ENVIRONMENTAL IMPACT ASSESSMENT (EIA) SCOPING OPINION

Application Number: 3/2021/0174

**Proposal: EIA SCOPING REQUEST FOR THE INSTALLATION OF
TUNNELLED PIPEWORK AT THE MARL HILL SECTION OF THE
HAWESWATER AQUEDUCT AND ASSOCIATED WORKS.**

Director, Highways and Transport,
Lancashire County Council

FIGURE 3.1A

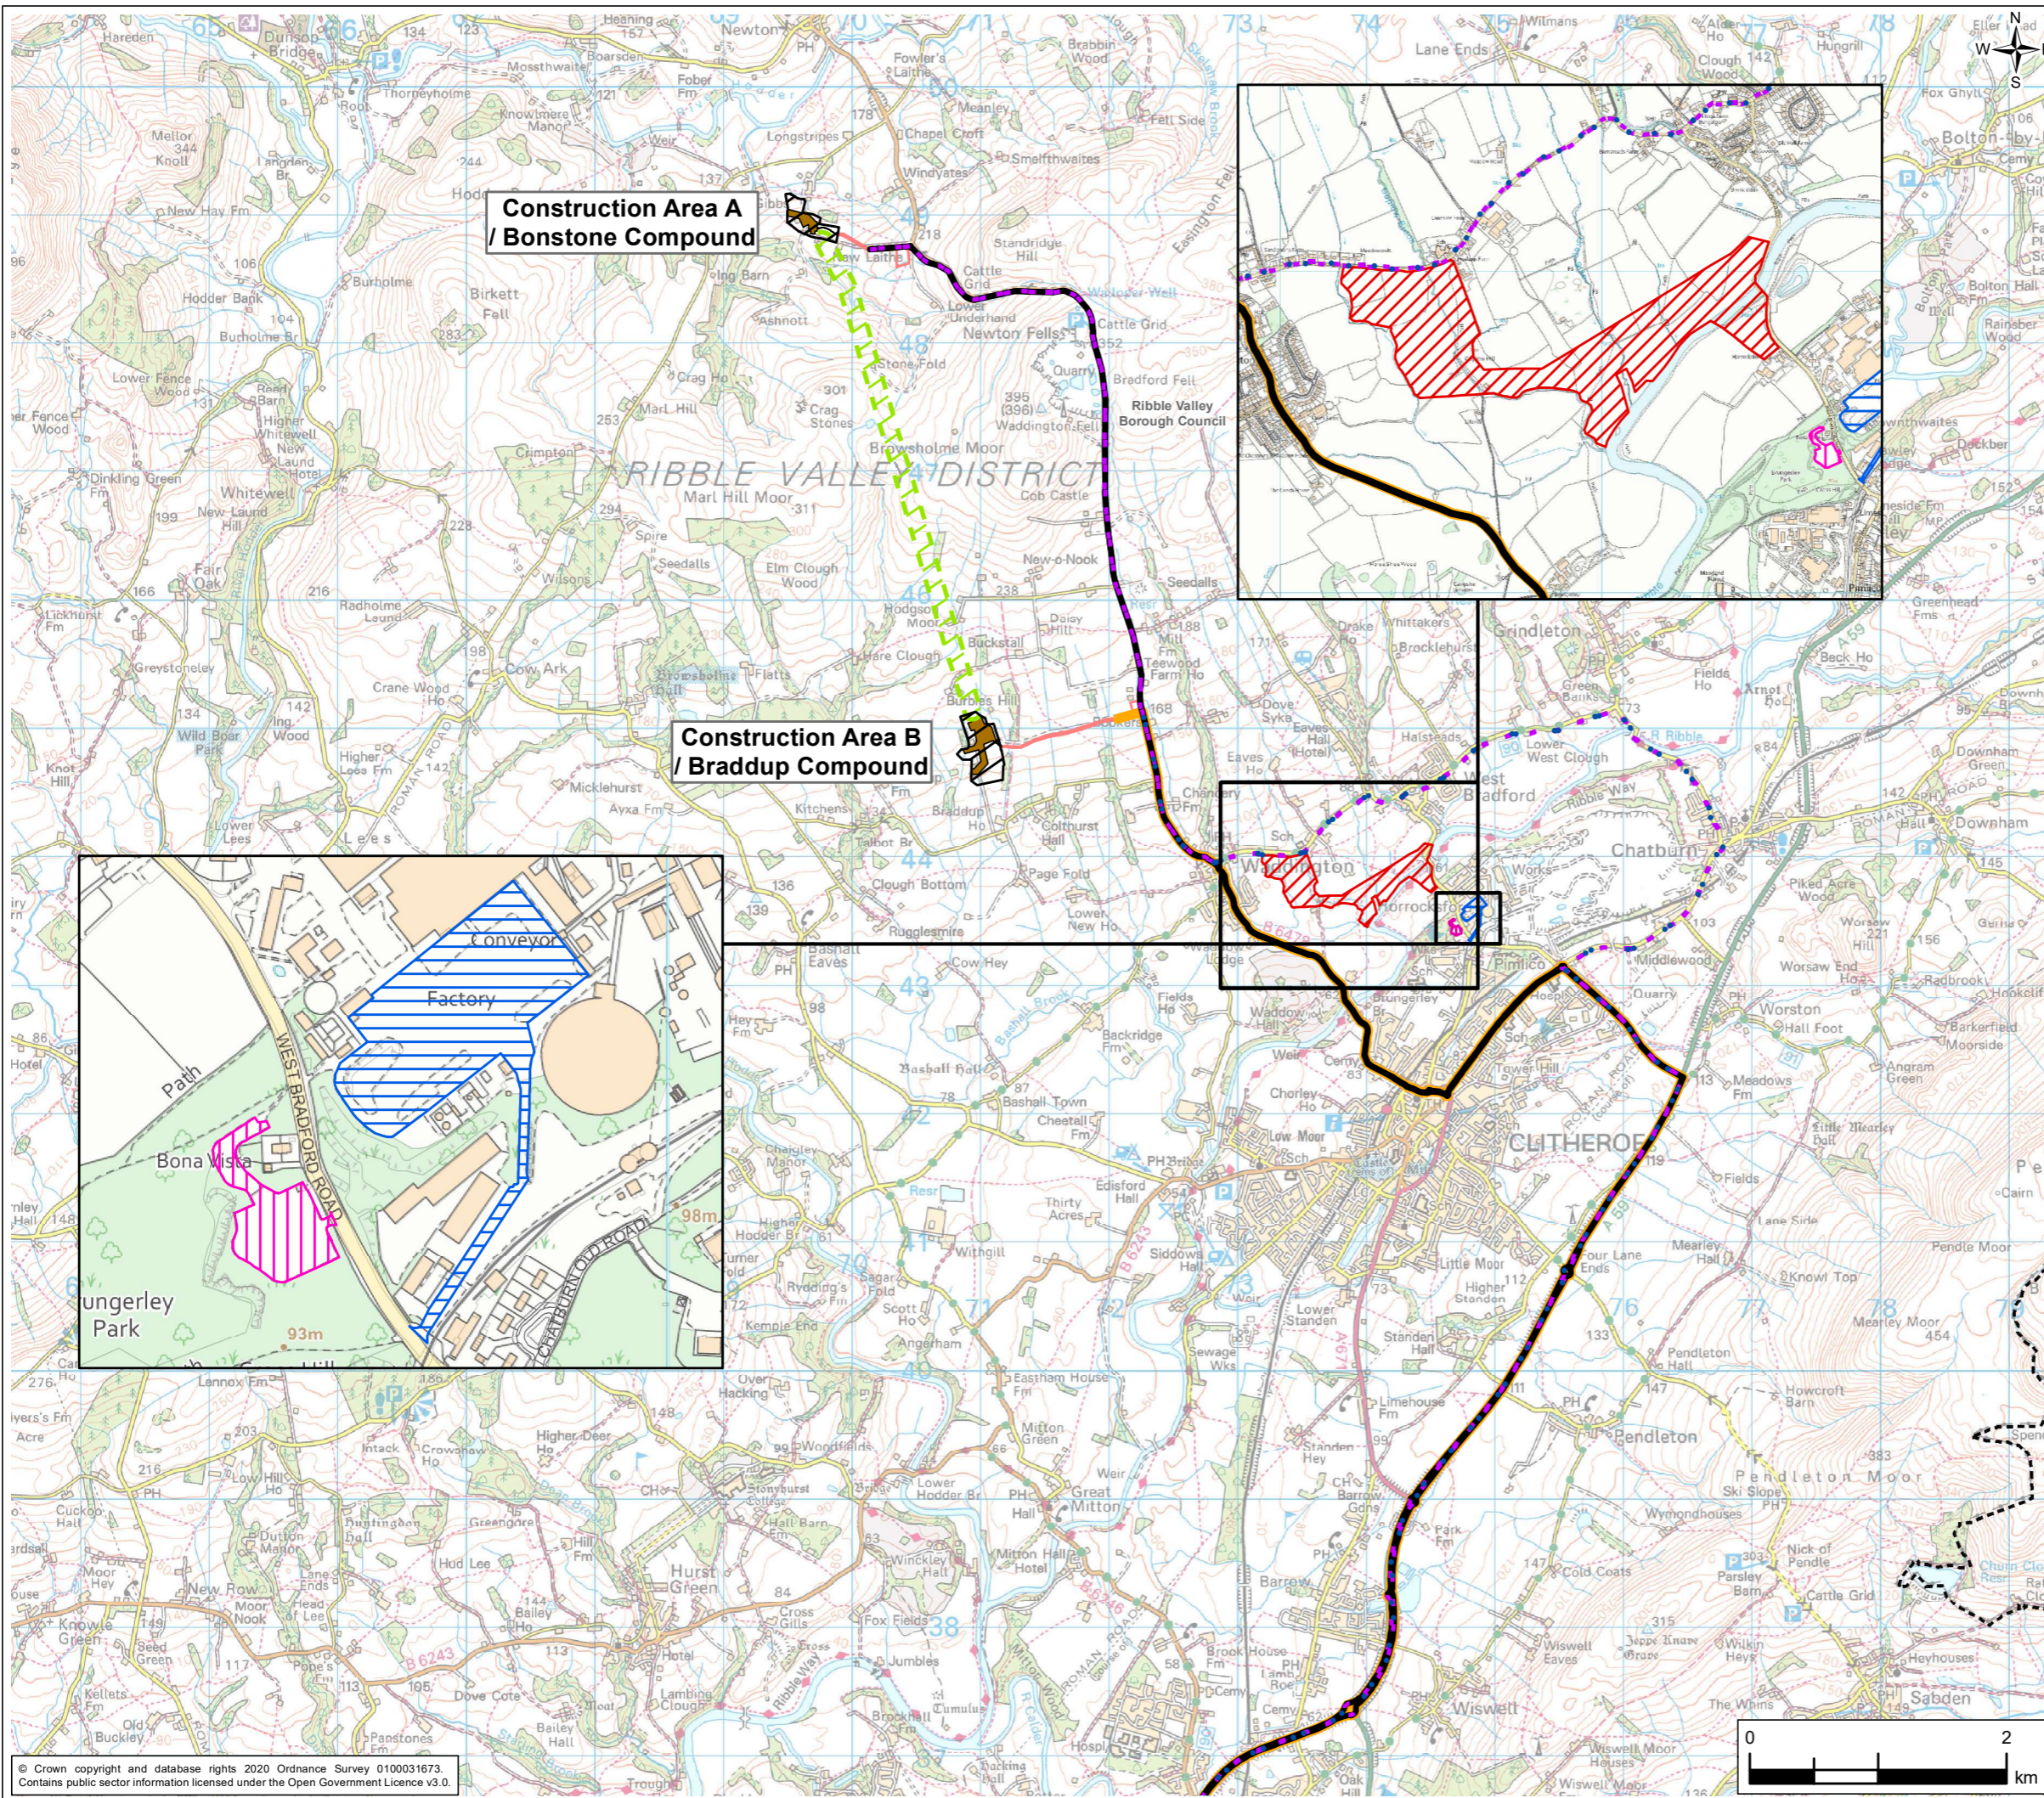
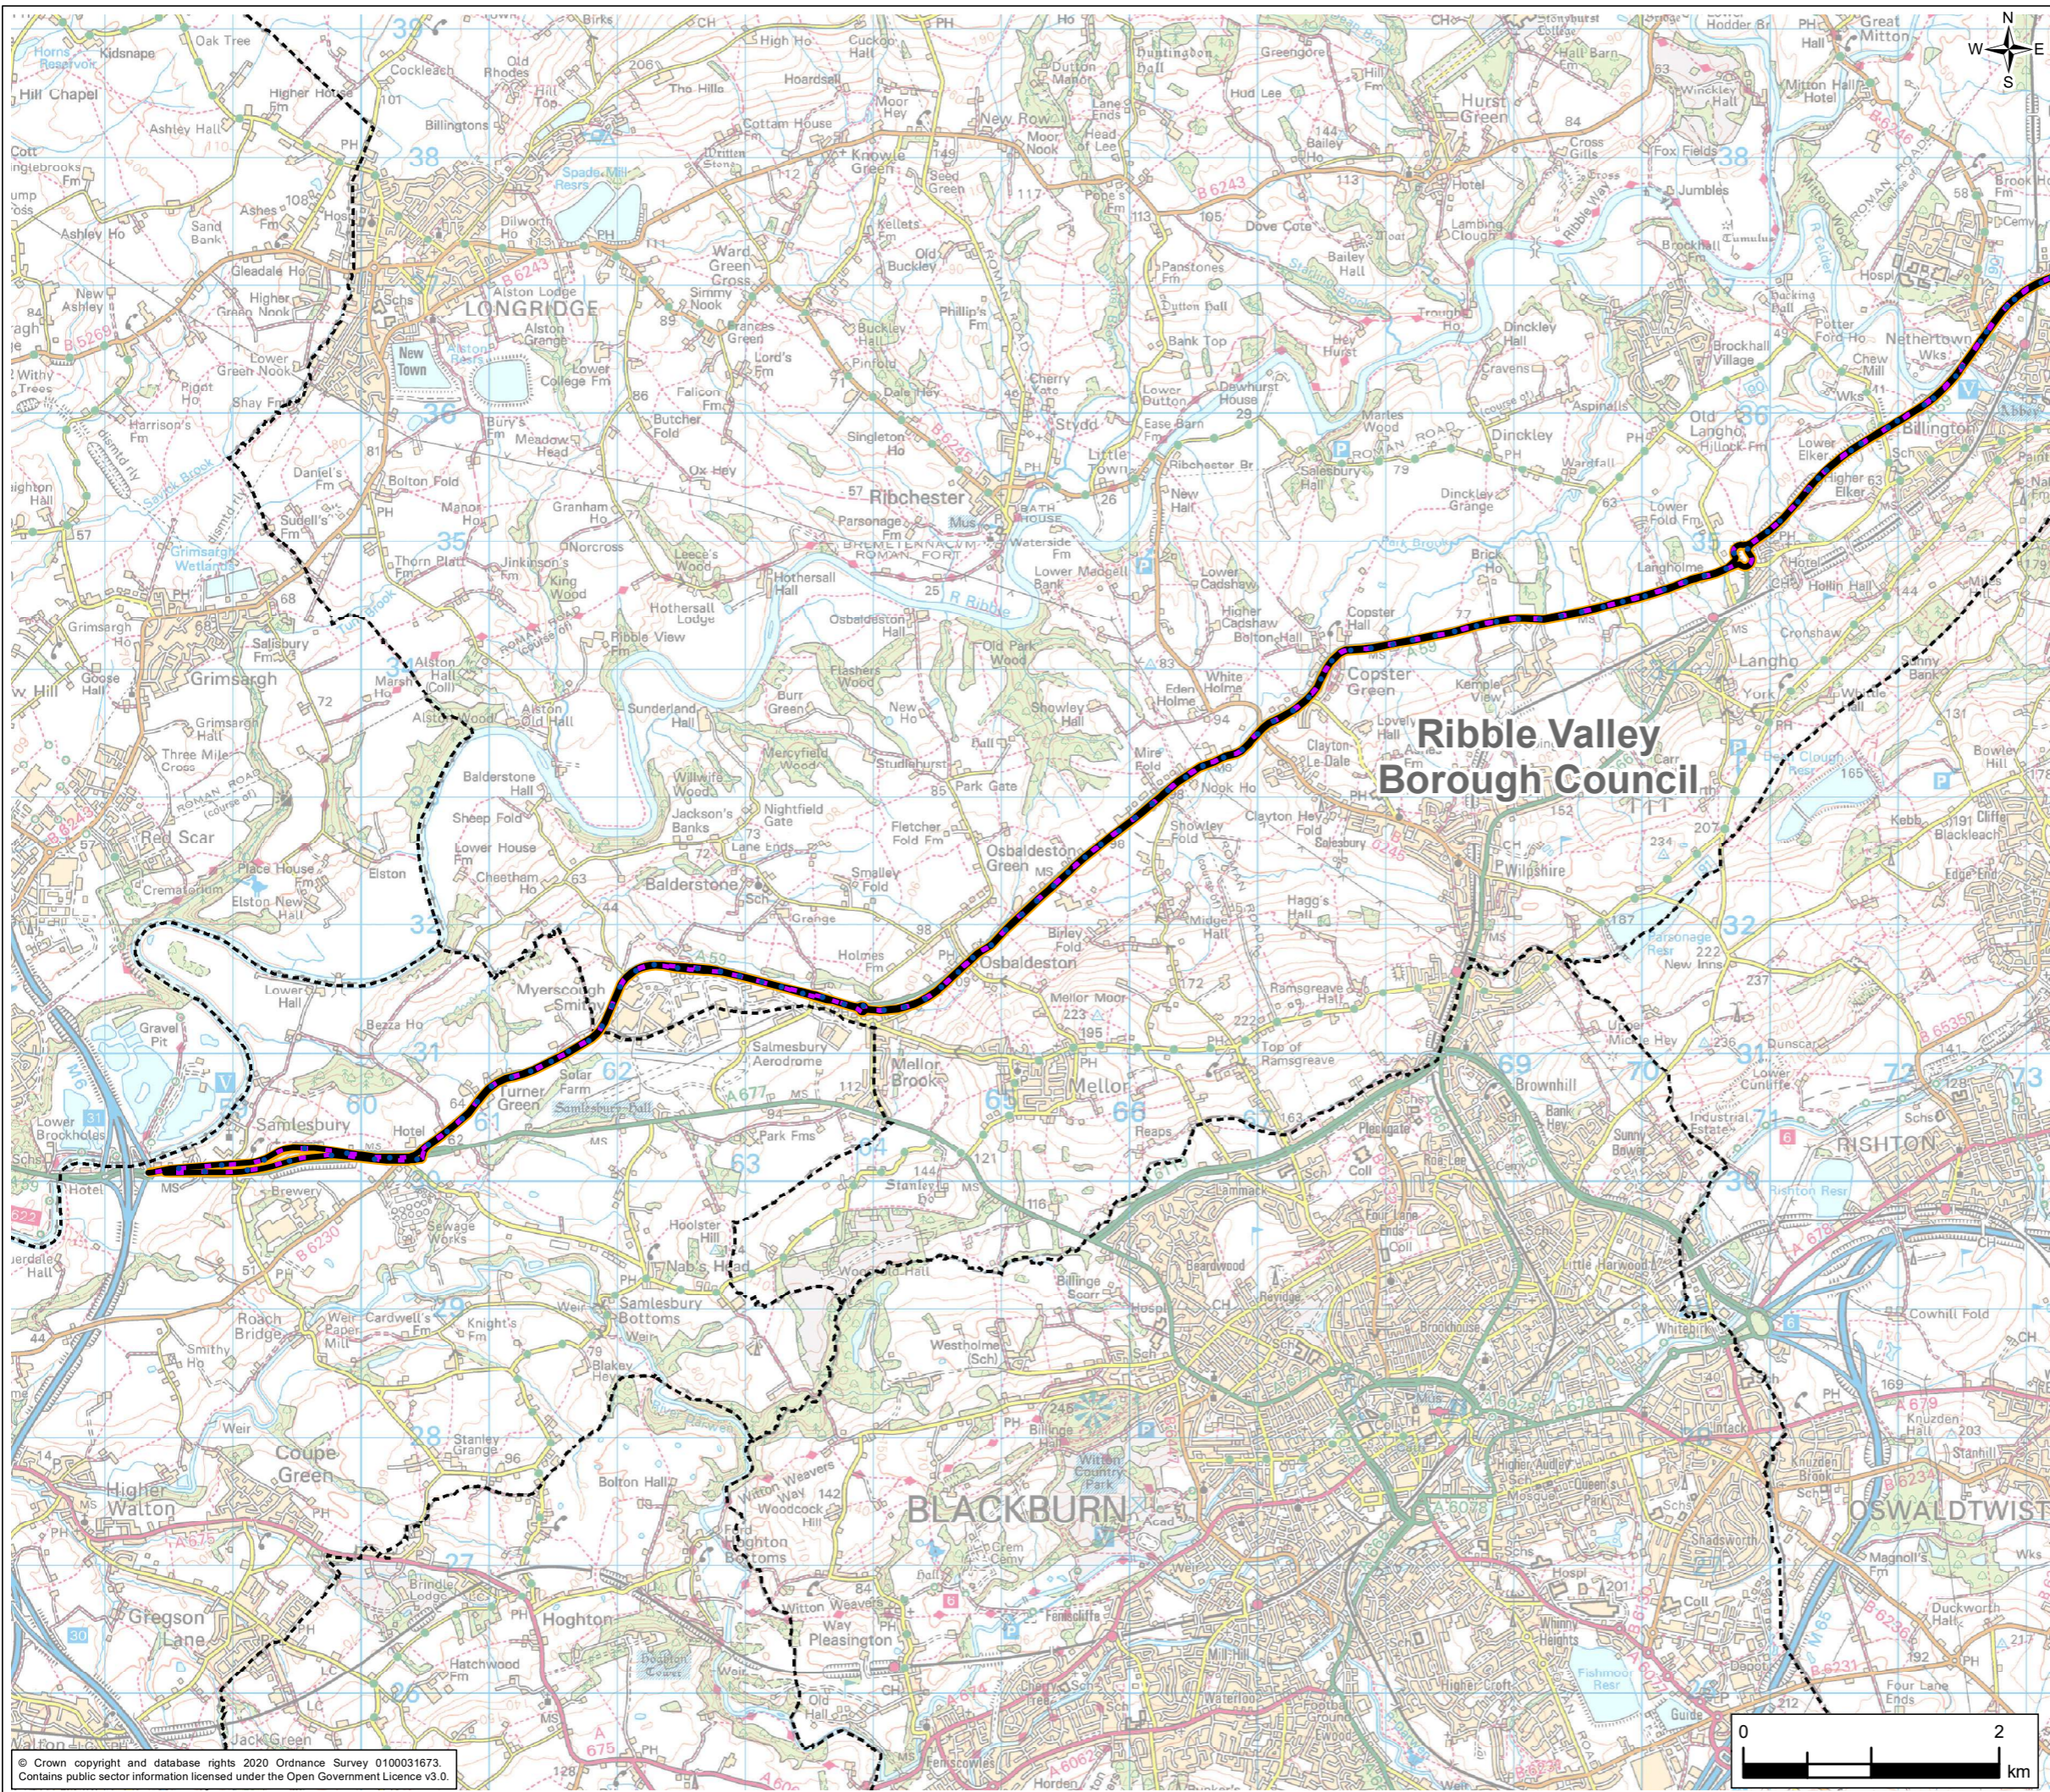
The EIA Scoping Report Addendum for the Proposed Marl Hill Section indicates there will be 2 No. Construction Areas (Labelled Areas A and B, both within Ribble Valley). Both of these areas can be expected to require vehicular access points that will influence the routing of construction traffic. As greater details are made available on all matters and in particular on vehicle movements and routes, as set out above, LCC Highways would expect to agree the detail of data that will be necessary. This detail will supplement the initial broad approach agreed during the early pre-application discussions.

The EIA Scoping Report Addendum sets out two transport routes (one through villages of Chatburn, Grindleton and West Bradford and one through to avoid the villages). The report states that both routes are mutually exclusive, and it is anticipated that only one would be taken forward for consideration at planning committee. The developers' transport consultant is continuing to provide information to support the latest vehicle access and routing options. LCC Highways would expect relevant details of the data that will be necessary to support the transport assessment and necessary traffic management plan for both proposals.
